Re: Additional items to be addressed - Trafalgar Avenue (SSD-79276958)

We write in response to your correspondence of 24 April 2026 seeking further submission on the following.

Drawing Name
Basement 1

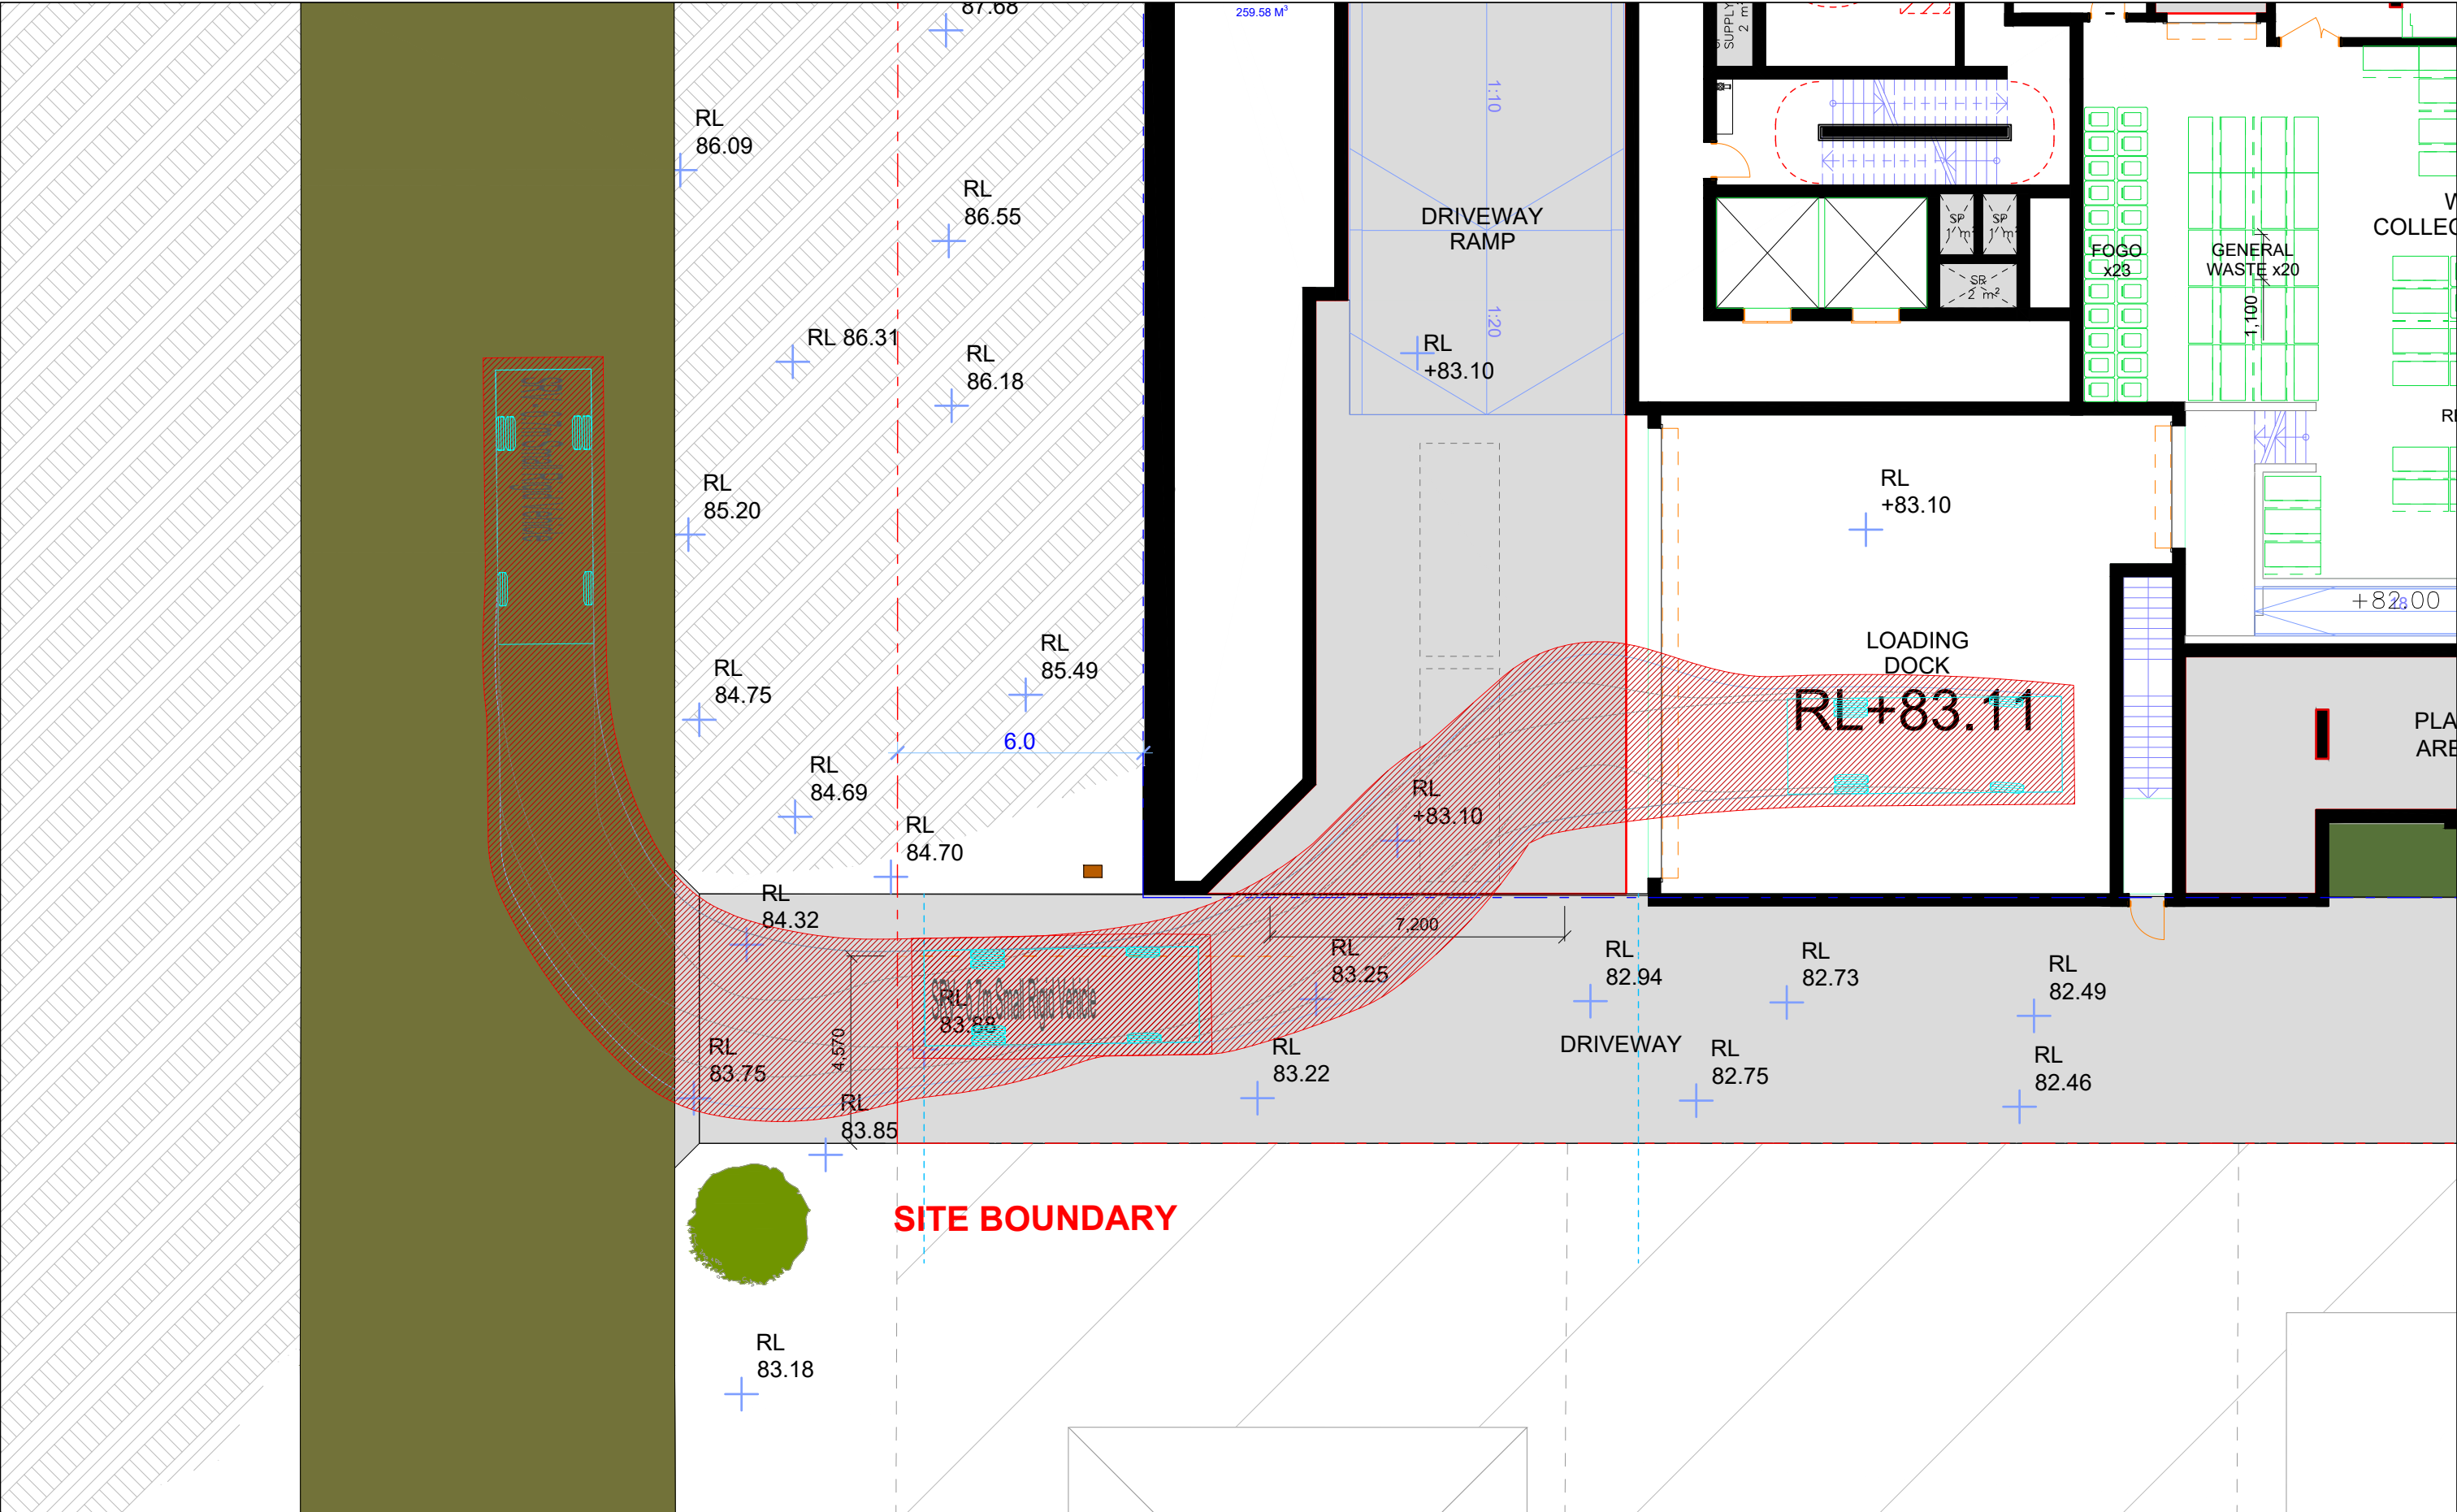
- Amendments to the architectural plans:
 - DA102 - Site Plan
 - Change to RL's
 - DA200, DA201, DA202 - Basement 1-3
 - Change to size, with no change to deep soil at ground floor

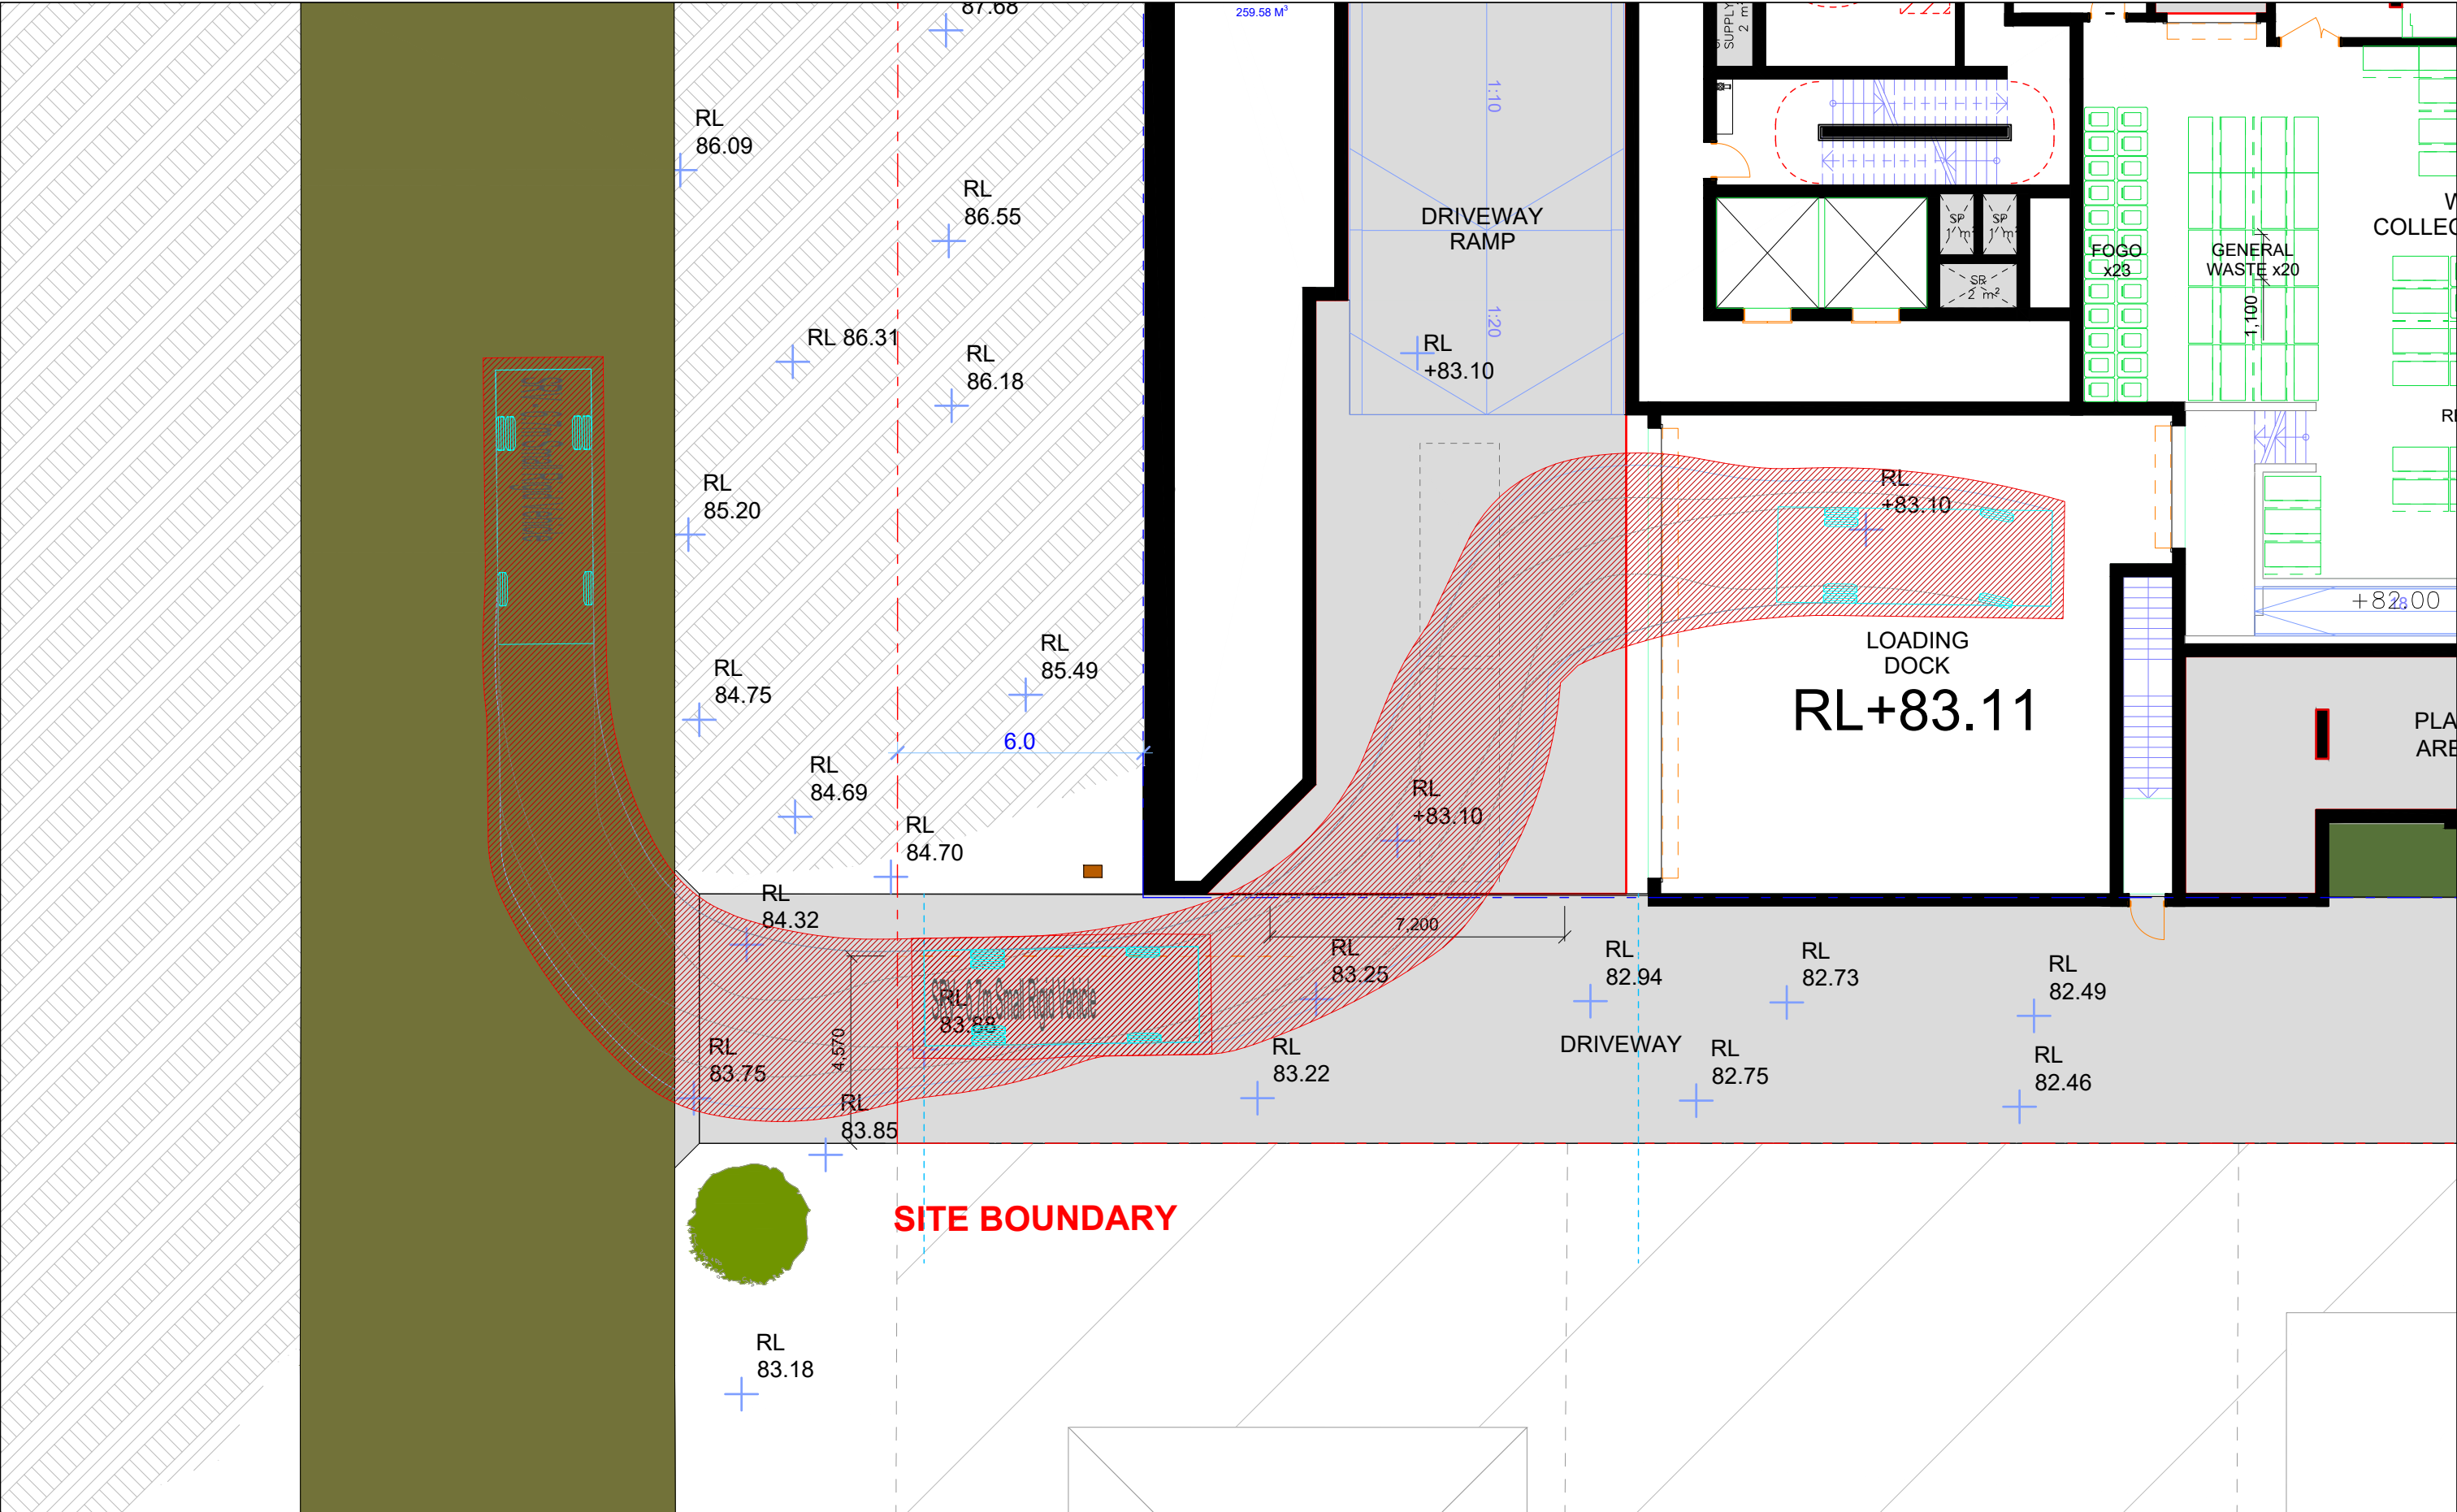
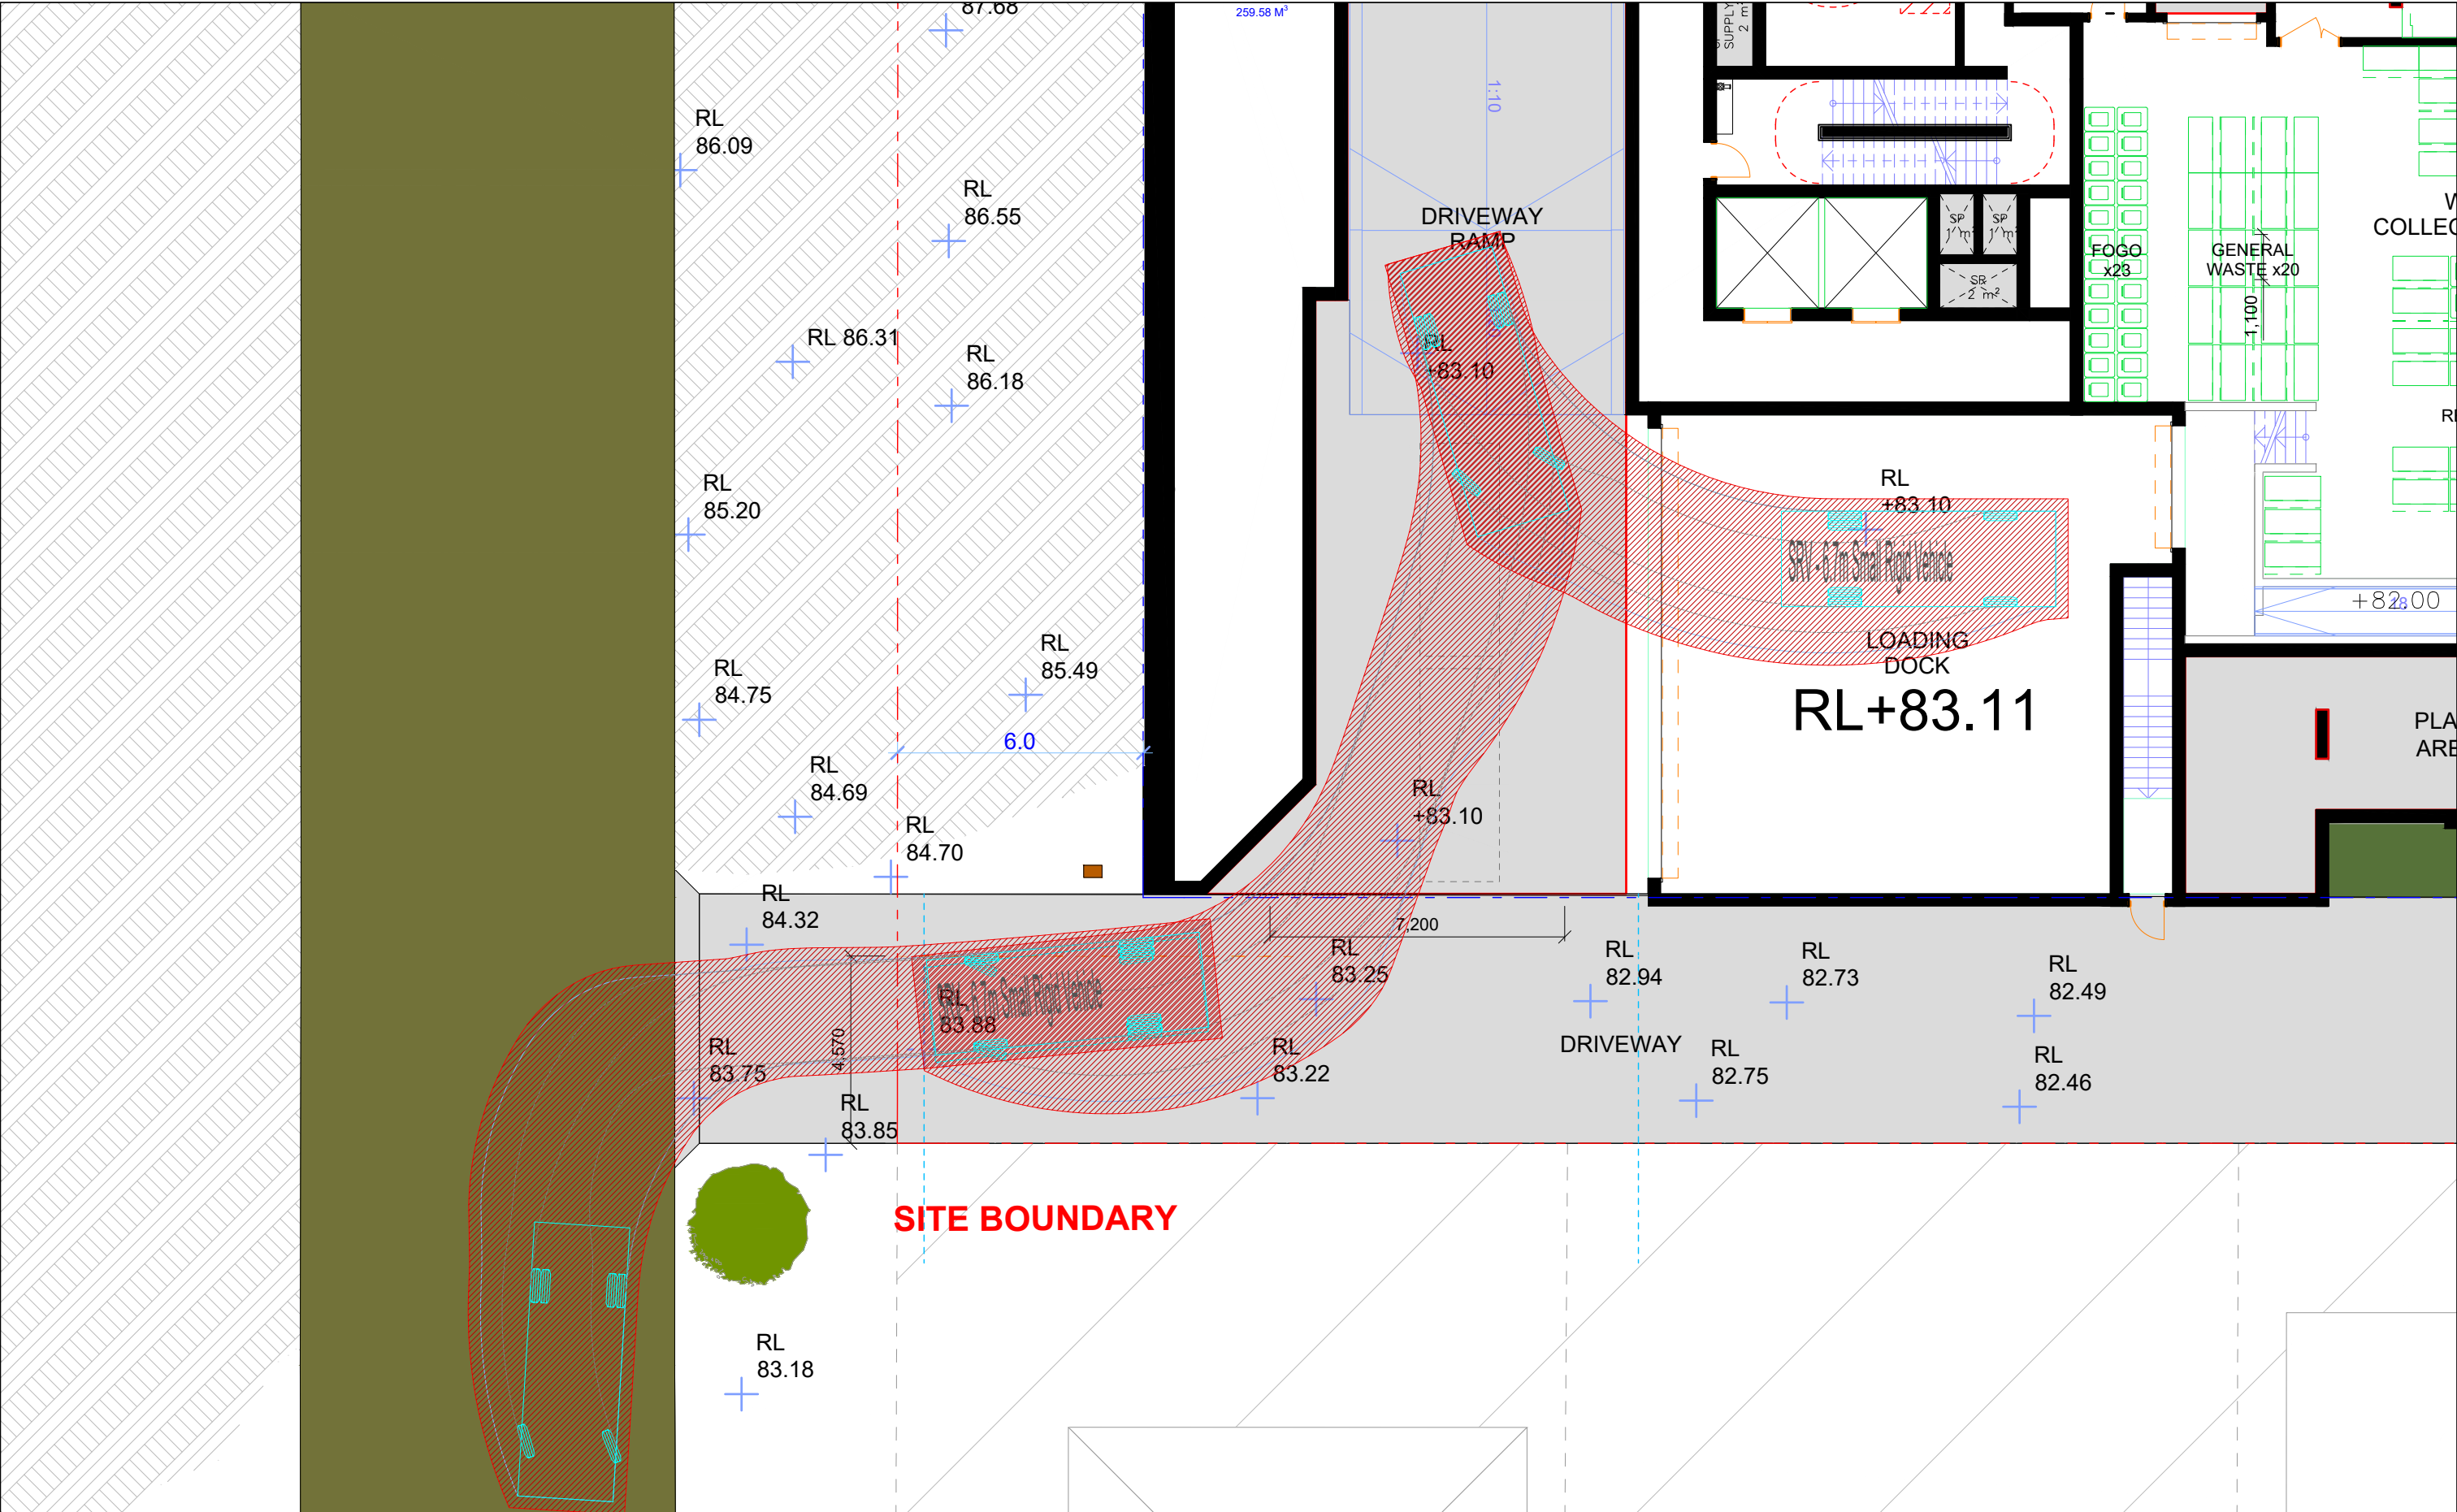
Section 4.8 of the Traffic Impact Assessment report confirms loading dock/waste collection has been designed to accommodate a 6.4m SRV as per the KDCP (Part C – 25A.5 (Point 16)). Notwithstanding, we have updated the TIA confirming 6.7m length and 2.6m height for the swept path of the SRV.
